42130-01-016
 Plat 4040
 lot 5.01 acres

PCD FILE
 NO. AL1827

VARIANCE SPECIAL
USE
ZONE R3
DATE: 1-3-93
OWN BY BILL MOORE
B/M CONST.

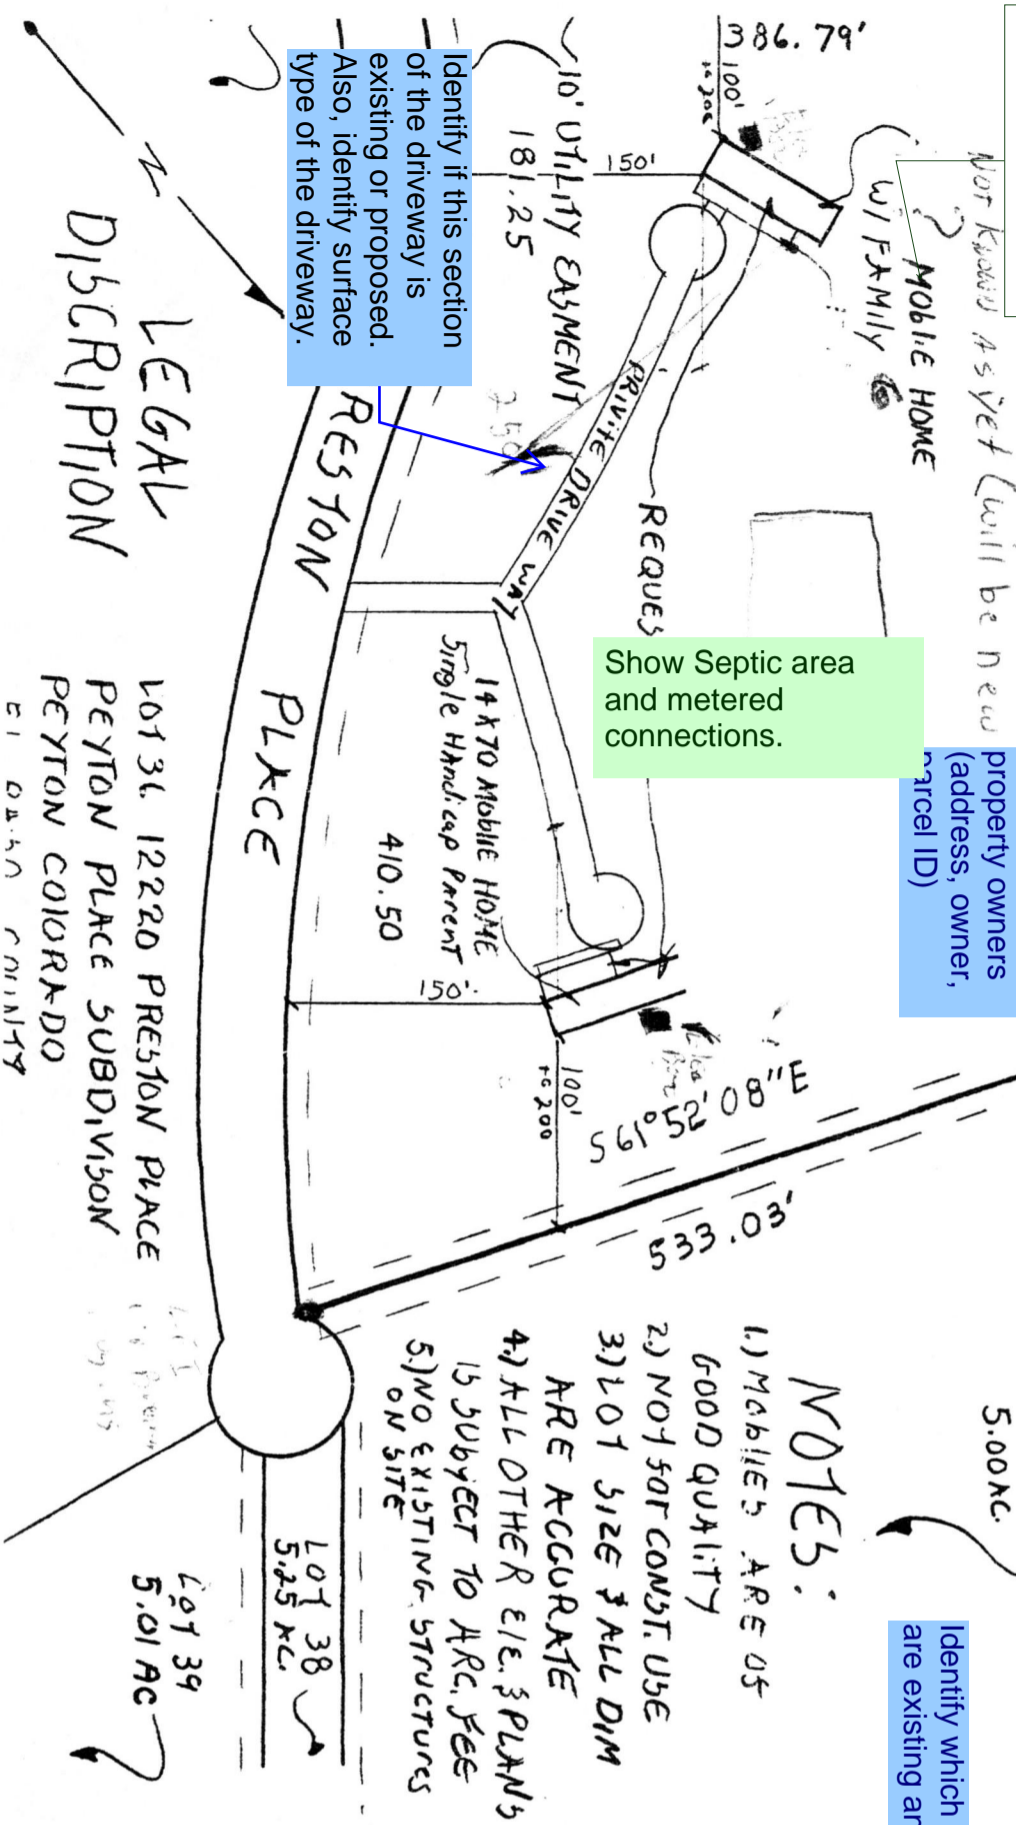
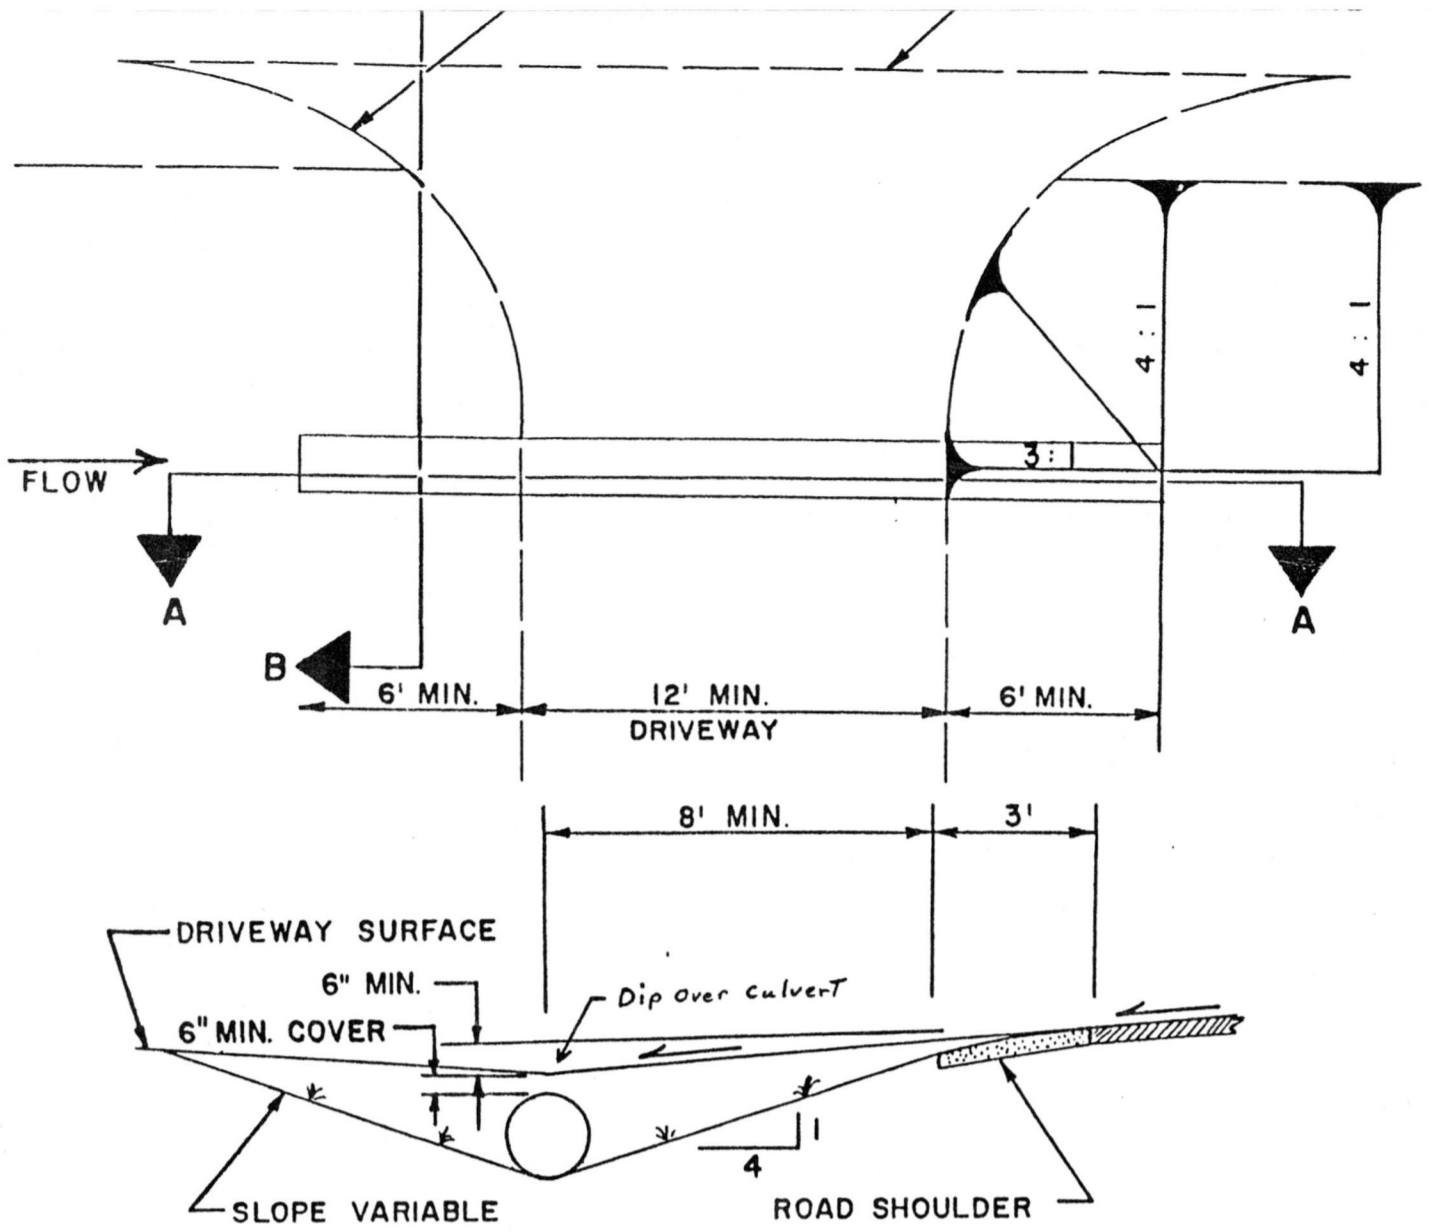
This is north, include an arrow.

This is north, include an arrow.
